Rezoning Transportation Analysis

Petition Number: 2020-017

General Location Identifier: Tax ID 11101102

Date	Description
03-18-20	First Review

RZ-1

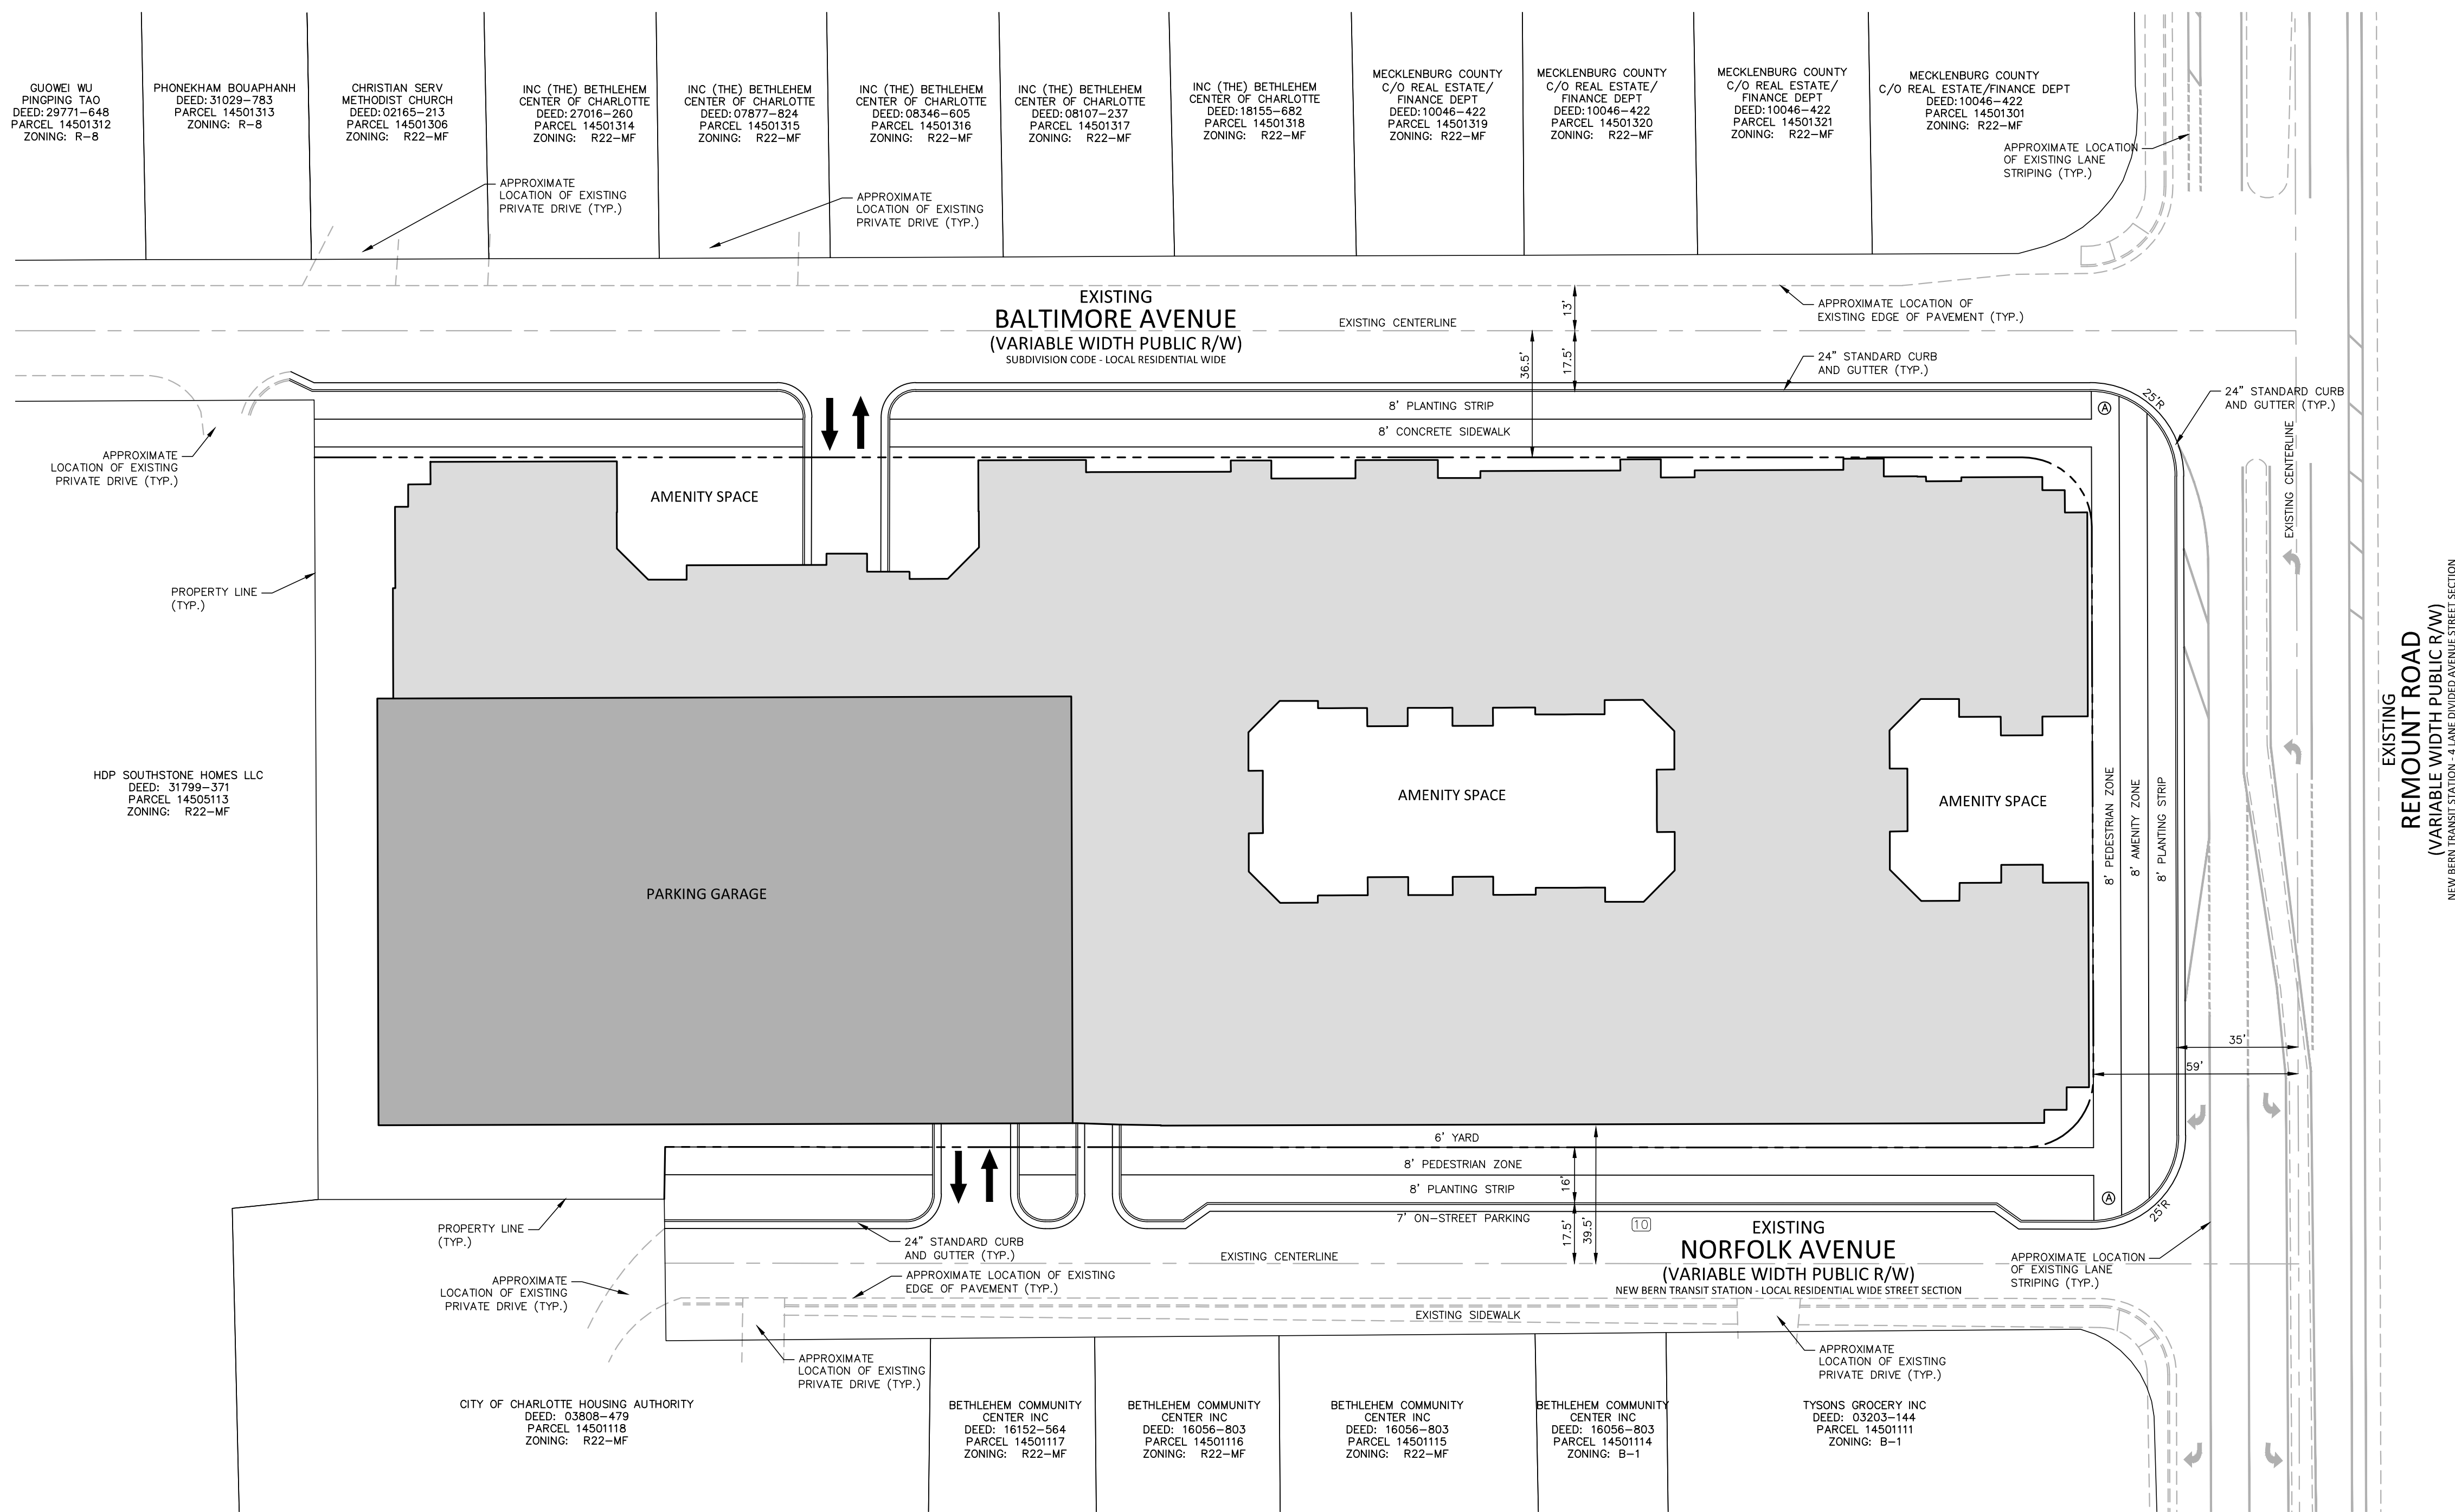
The site is located on a minor thoroughfare. The petitioner should revise the site plan to meet the ordinance requirements and the outstanding items listed below. With consideration to the Vision Zero Action Plan, CDOT requests pedestrian improvements at the intersection of Baltimore and Remount Road, which is classified within Charlotte's High Injury Network. Charlotte WALKS was also applied to improve pedestrian connectivity. This rezoning petition is also located near rezoning petition 2020-018.

- The petitioner should revise the site plan and conditional note(s) to account for on-street parking curb extensions, if on-street parking is desired by the petitioner. The petitioner should clarify if the on-street parking will be marked or unmarked. If marked, the parking spaces may count toward the Zoning Ordinance parking count requirements but will also require accessible on-street parking per the Charlotte Land Development Standards Manual (CLDSM). The 25' intersection radius is acceptable and is consistent with Urban Street Design Guidelines (USDG) Appendix C.

- We request the petitioner to revise the site plan and conditional note(s) to construct a pedestrian refuge island across Remount Road, in reference to the Vision Zero Action Plan and enhanced intersection crossing included within the New Bern Area Plan. CDOT has notified Mecklenburg County of the possibility of the petitioner possibly attaining public utility and construction easements to improve the streetscape at this intersection. Please contact Jacqueline McNeil at (Jacqueline.McNeil@mecklenburgcountync.gov) or (980-314-2511) and Bert Lynn at (Bert.Lynn@mecklenburgcountync.gov) or (704-589-7491). The pedestrian refuge may be unsignalized, but should still include MUTCD pedestrian crossing signage with a marked crosswalk. Please provide CDOT with an exhibit to review.

- The petitioner is required to revise the site plan and conditional note(s) to widen the proposed access on Baltimore Avenue to a CLDSM standard for two-way traffic.

- The petitioner is required to revise the site plan and conditional note(s) to coordinate with the petitioner of 2020-018 to align the proposed access with one of the two proposed driveways with within rezoning petition 2020-018's proposed site plan, or vice versa.

- In reference to the Charlotte WALKS adopted plan, the petitioner should revise the site and plan and conditional note(s) to replace the existing driveway to a CLDSM standard, to the extent possible within the public right of way, to properly connect the proposed sidewalk into the existing sidewalk to improve accessibility.

8. The petitioner should revise the site plan and conditional note (Section IV. Transportations, 3) to add specify dedication and fee simple conveyance of **all** rights of way to the City before the site's first building certificate of occupancy is issued. CDOT requests right of way set at 2' behind back of sidewalk where feasible.
9. The petitioner should revise the site plan and conditional note(s) to remove the proposed access on Norfolk Avenue, as shown below.

10. The petitioner should revise the site plan and conditional note(s) to clarify if the Norfolk Avenue on-street parking will be used to count toward Zoning Ordinance parking requirements. If so, one accessible on-street parking space will be required, affecting the proposed streetscape along Norfolk Avenue.

11. In reference to the Charlotte BIKES adopted plan and CDOT Streets Map, CDOT requests the petitioner to revise the site plan and conditional note(s) to restripe the area below to replace the existing eastbound right turn lane in favor of extending the buffered bike lane to the intersection of Tryon Street. This request is also supported to establish a constant bike facility connection to the Rail Trail directly into South End.

12. The petitioner should revise the site plan and conditional note(s) to clarify the trash container locations and how handling will be performed. The petitioner should provide all the

13. The petitioner should revise the site plan and conditional note(s) to include the location of Zoning Ordinance required bicycle parking.
